Your Ref: 2020/93954
Our Ref: W016690

30th December 2020

Land at Lingards Road , Slaithwaite, Huddersfield - Erection of 57 dwellings and associated works

Dwn	Chkd	Date	Scale	Dwg No.
HH		SEPT-19	1:500@A1	E19/7567/001F

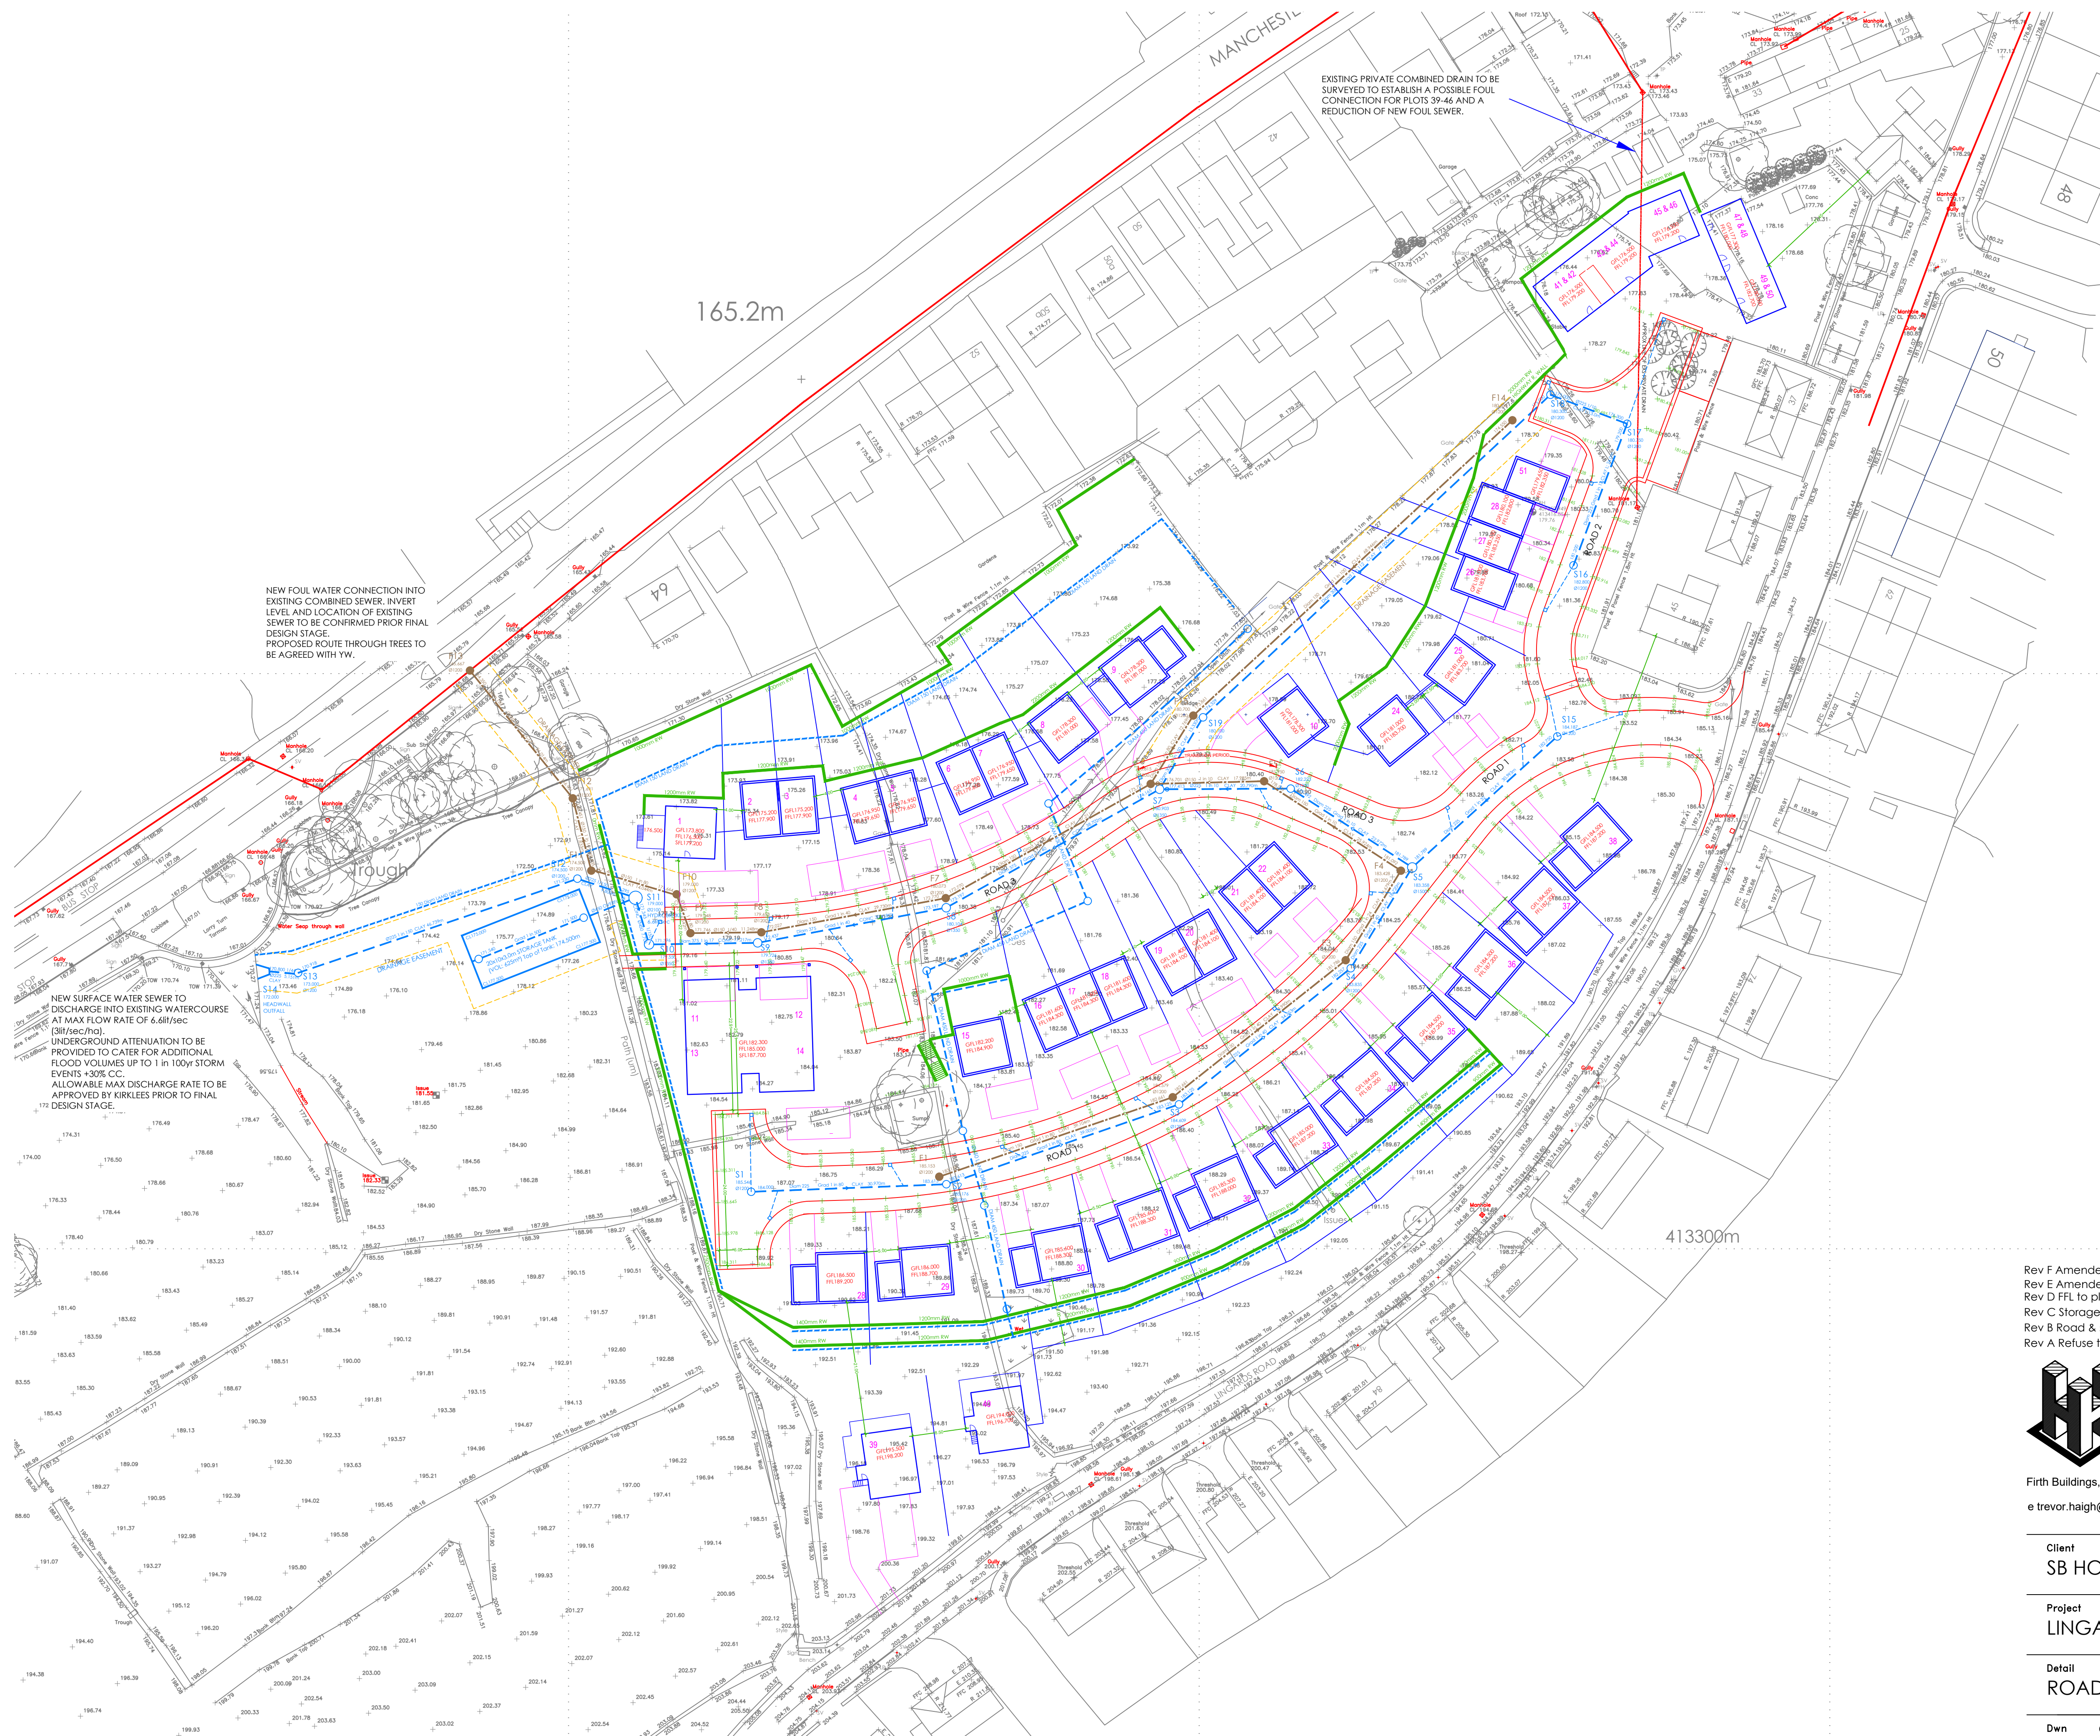
- 1) The proposed separate systems of drainage on site and off site
- 2) The proposed amount of domestic foul water to be discharged to the public combined sewer network
- 3) The proposed point of discharge of foul water to the public combined sewer in Manchester Road

submitted on drawing E19/7567/001F (revision F) dated 26/11/2020 prepared by Haigh Huddleston & Associates that also shows surface water proposed to be drained to watercourse.

Provided that, if planning permission is granted, drawing E19/7567/001F (revision F) dated 26/11/20 is included within the list of approved documents YW has no further comment on this application.
